Planning Inspectorate reference: EN070008

APPLICATION BY CHRYSOR PRODUCTION (UK) LIMITED (THE APPLICANT) FOR A DEVELOPMENT CONSENT ORDER FOR THE VIKING CCS PIPELINE (EN070008).

NOTIFICATION OF INTENTION TO SUBMIT AN APPLICATION FOR CHANGE REQUEST

Drawing title
**LOUTH ROAD
BLOCK VALVE STATION
(BVS3)
Regulation 5.2 (o)
Application Document Reference 4.16
(Sheet 1 of 1)**

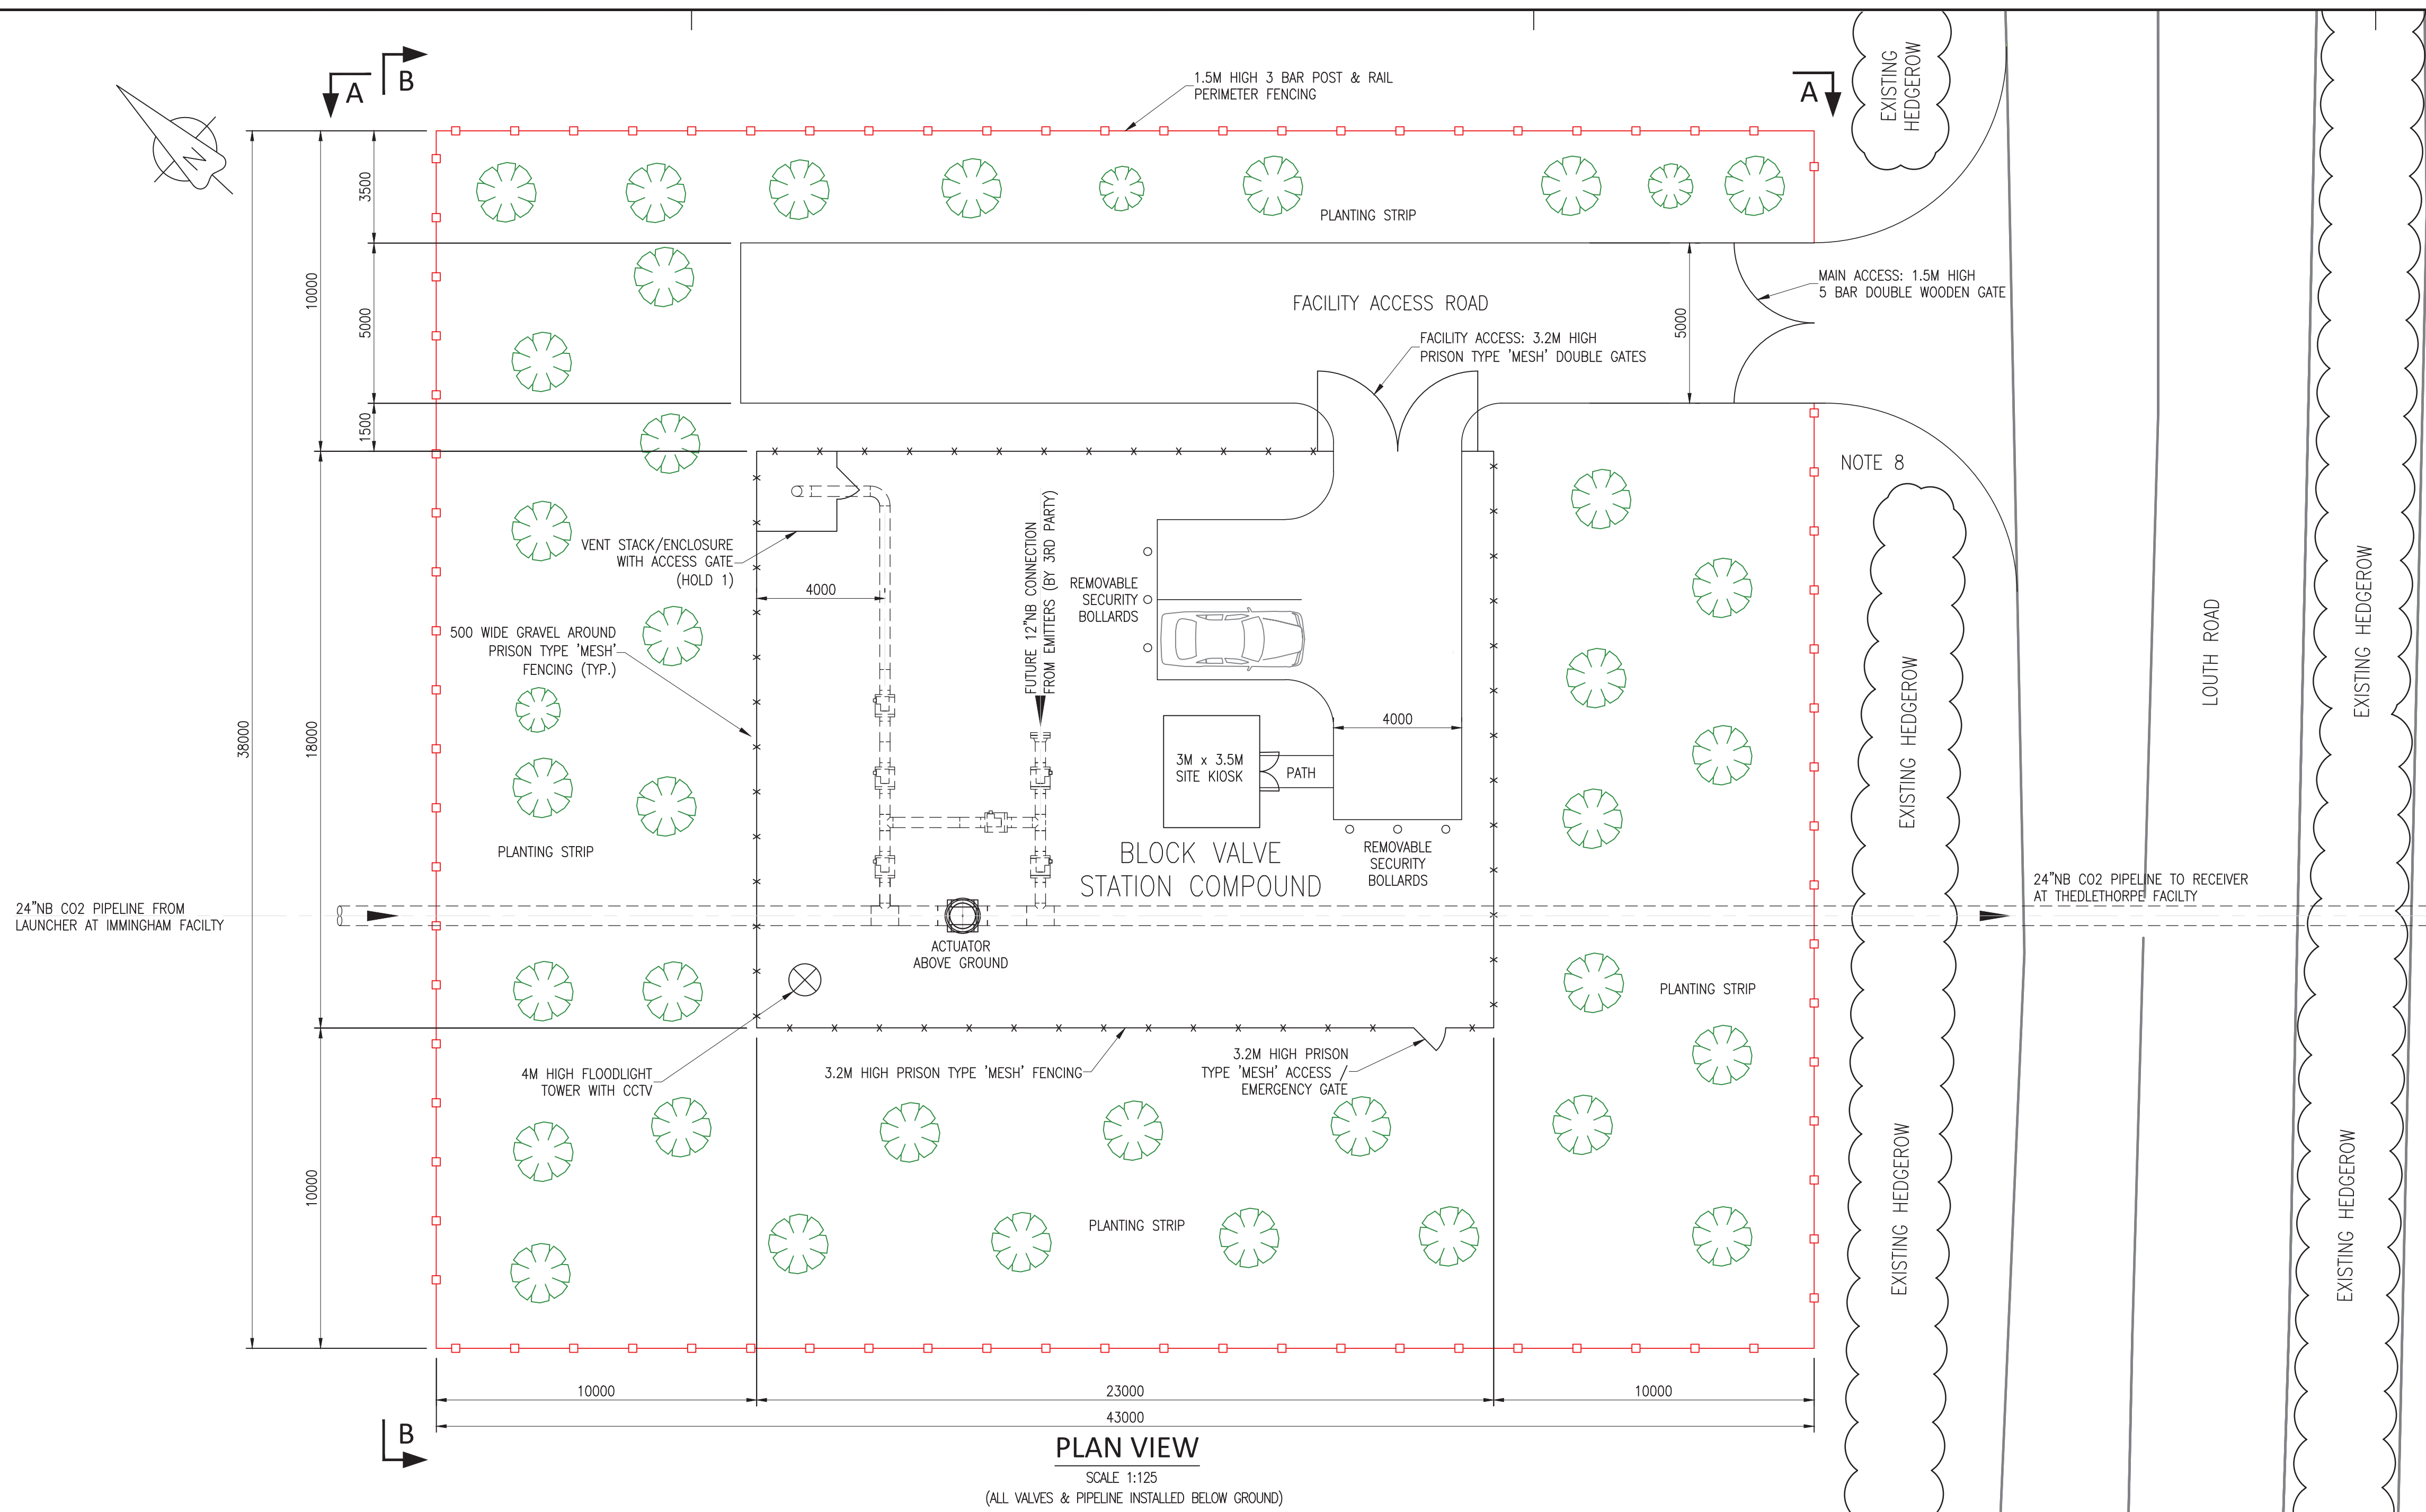
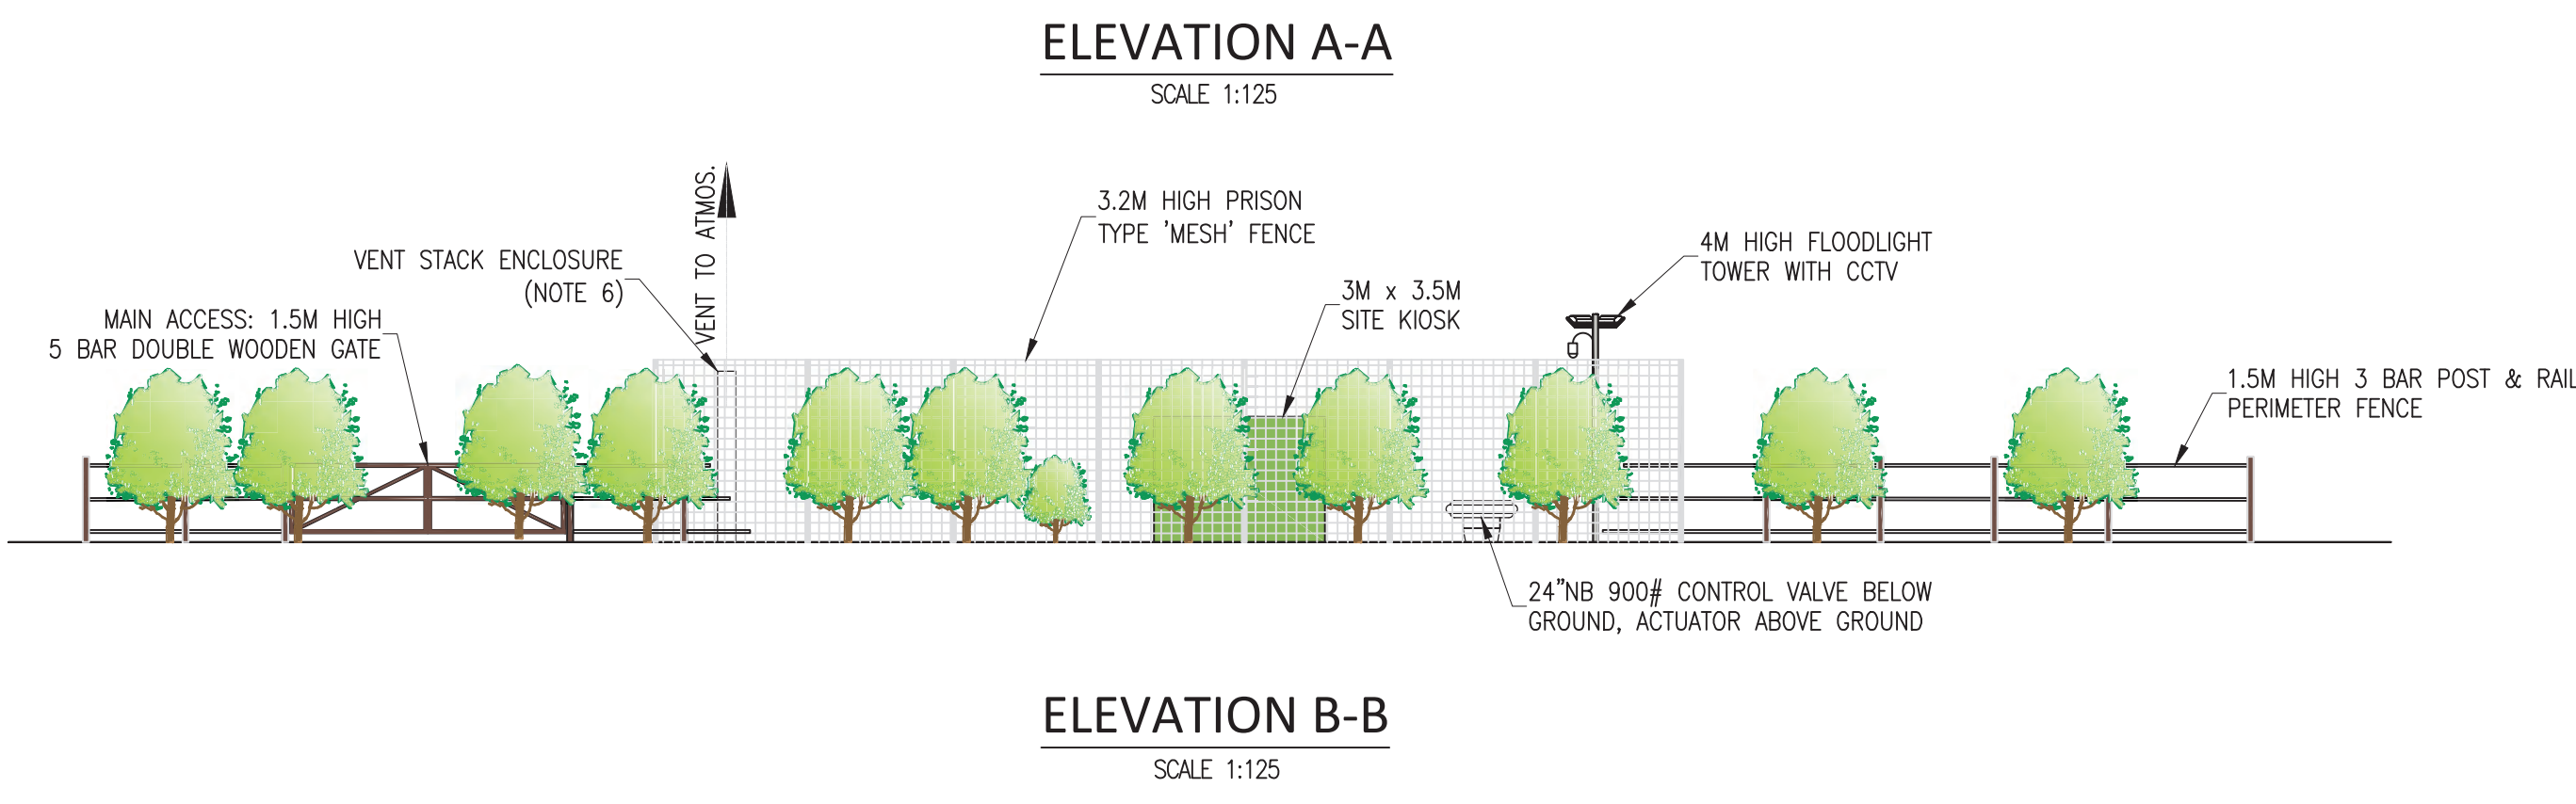
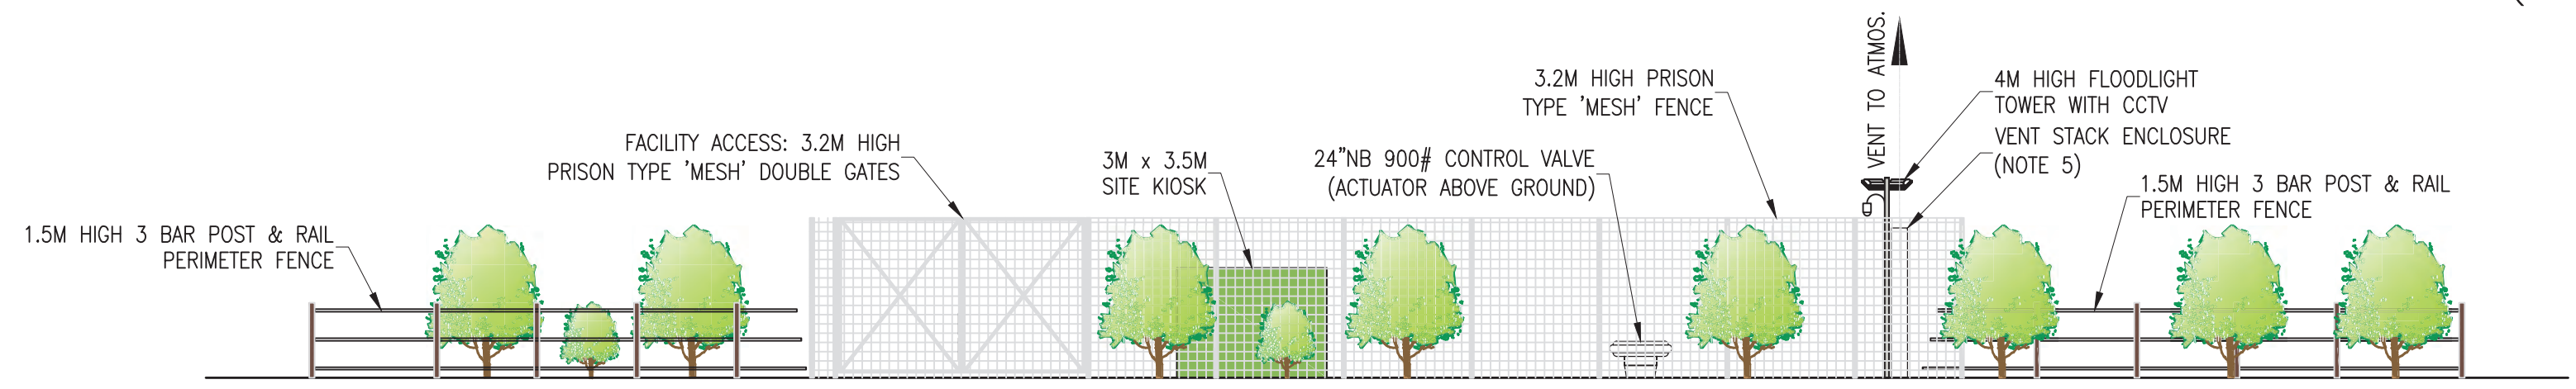
Change 3: Relocate Block Valve Station 3 (Louth Road BVS) to the south of Louth Road near Alvingham within the existing Order Limits (Modification of Works Nos. 31, 31a, 31b and 32a).

The Proposed Development includes three Block Valves Stations (BVS) along the pipeline route to enable pipeline sections to be isolated for operational and maintenance reasons. BVS 3 (Louth Road BVS) is currently located on agricultural land to the north west of Louth Road near Alvingham (Work No. 31). The permanent footprint of the proposed BVS is approximately 43m x 38m.

Prior to submitting the Application, the Applicant had not received any feedback from the landowner (Mr Shucksmith) on the location of Louth Road BVS. However, following submission, the landowner has requested that Louth Road BVS be moved to the opposite side to the south east of Louth Road, which is an area of land owned by the same party. The Applicant understands that the proposed location would have a lower impact on the landowner’s agricultural operations. The Applicant has now completed feasibility studies and has concluded that it is feasible to locate the Louth Road BVS on the south east side of Louth Road. The Applicant will therefore request to make the proposed change.

The Proposed Development currently provides for a temporary access and laydown location (Work No. 32a) to the south east of Louth Road, which would be relocated to the north west side of the road.
